**NEW MEXICO  
ENVIRONMENT DEPARTMENT**

**Re: Hutton Exchange Albuquerque (Coors), LLC. / O'Reilly Auto Parts (Coors); Construction Stormwater; SIC 1542; NPDES Compliance Evaluation Inspection; NPDES # NMR1001DZ; May 21, 2019**

## NPDES Compliance Inspection Report

### NPDES Construction General Permit Inspection Report – State of New Mexico

DRAINAGE MANAGEMENT PLAN

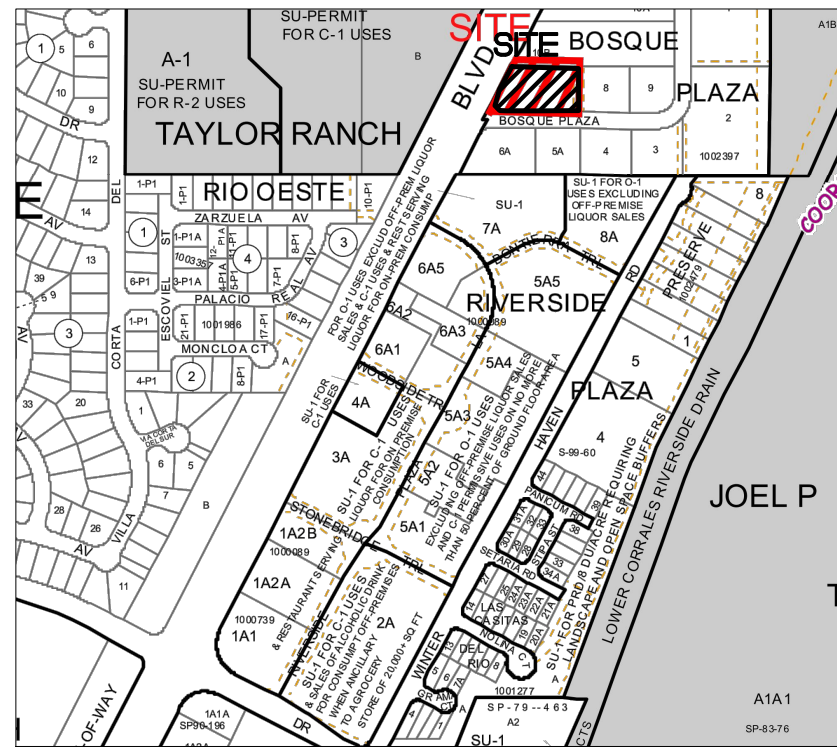
The project is the construction of a commercial building and is in the landscaping phase. The main area of development is shown as 0.776 acres on the site map and described as 1 acre in the SWPPP and NOI. However, the driveway and staging area are on the adjacent lot and do not seem to be included in totals. At the time of inspection, the inspector did not understand that there were multiple permittees for the Project. The inspector spoke with HBC Construction during the inspection and a representative for the owner was onsite as well. Mr. Robert Duncan, SWPPP contact for Hutton Exchange, did not respond to the inspector's phone message or email. The SWPPP consultant provided electronic documents after the inspection and stated that Hutton Exchange has both Operational and Day to Day control at the site.

When the inspector arrived, the Operators were just finishing shoveling the gutters clean of sediment. BMPs have been removed except for the far east end. The water quality pond had not yet been constructed as utilities had been located within it and need to be relocated (photo 1). It is unclear if the water quality pond and discharge culvert was sized to accommodate the two 36" DOT culverts that discharge to the site, the map states the pond is slightly undersized to meet the local ordinance.

- Part 7.2.4/7.4 The site map in the SWPPP did not show current site conditions or dates of installation/removal of BMPs.
- Part 7.2.6.vi The plan did not describe specific vegetative and/or non-vegetative practices that will be used or schedule for initiating stabilization
- Part 7.2.10 The SWPPP was not certified by HBC Construction before the NOI was obtained.
- Part 7.3 The SWPPP was not available at the time of the inspection.

- Part 9.4.1.c The SWPPP does not document that site specific practices will result in flow velocities that are not greater than predevelopment conditions.
